Report to Inspector (Technical appendix to main report) ABP- 314602-22

DevelopmentGortyrahilly wind farm near
Ballyvourney Co. CorkType of ApplicationStrategic Infrastructure DevelopmentTopic:Adequateness of information for
purpose of Environmental impact
assessment: OrnithologyEcologistMaeve Flynn BSc. PhD. MCIEEMSenior Planning InspectorKaren Hamilton

**Title**  
 Site Layout Keyplan

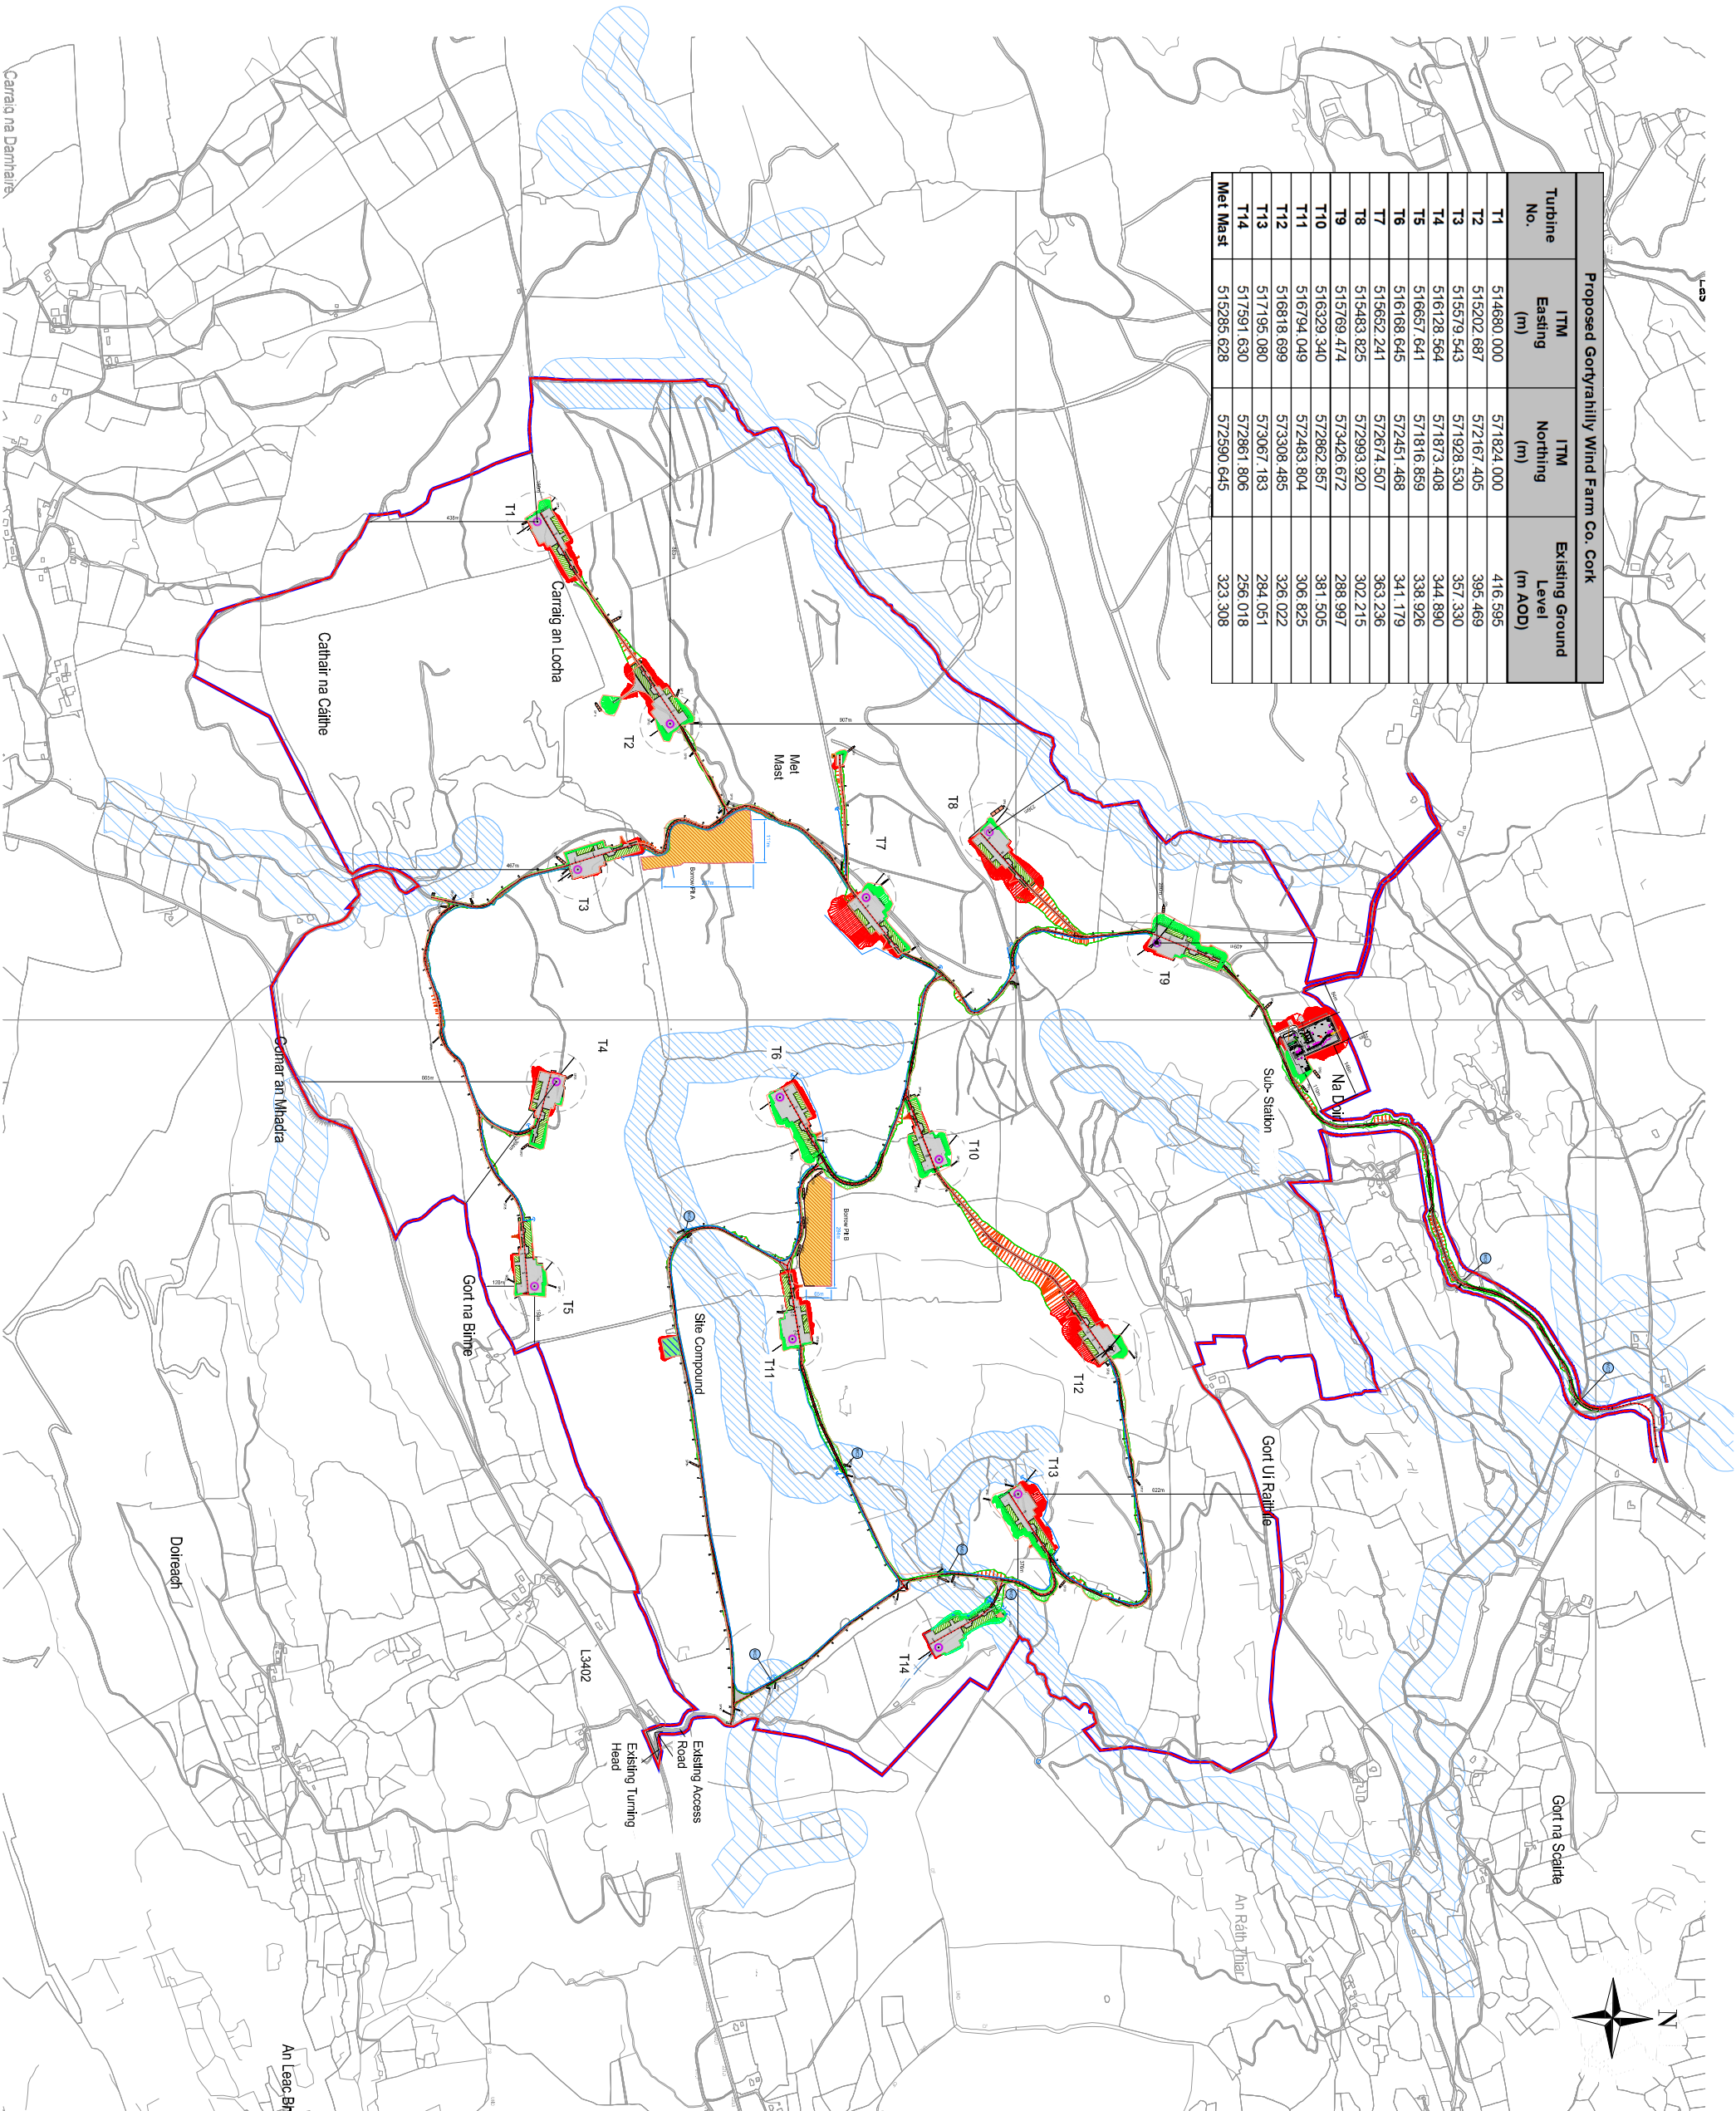
habitats.	
Data on previous burning	Some evidence of	Addresses request.
of vegetation on windfarm	recent burning between	
site	T8 and T9 but no data	Overall positive effect
		for ground nesting

Turbines T1, T2, T7 and T12 appear to be located on top of steep ridges. Assess if models designed to determine orographic lift are applicable at this windfarm (Hanssen *et al* 2020)³ Consider that the model is appropriate where high breeding density of eagles (as in Norwegian study referenced). The Norwegian study monitored up to 17 white tailed eagles fitted with GPS tracking devices.

Scarcity of While-tailed Eagles in the area combined with lack of suitable breeding habitat and significantly differing habitats and landscape scale features used to justify the unsuitability of the model to Gortyrahilly site. Applicant assessed applicability of suggested model and found that it wasn't suitable in this local context.

Applicant examined the referenced scientific study and I consider it reasonable to accept the justification for it not being suitable in the Gortyrahilly context.
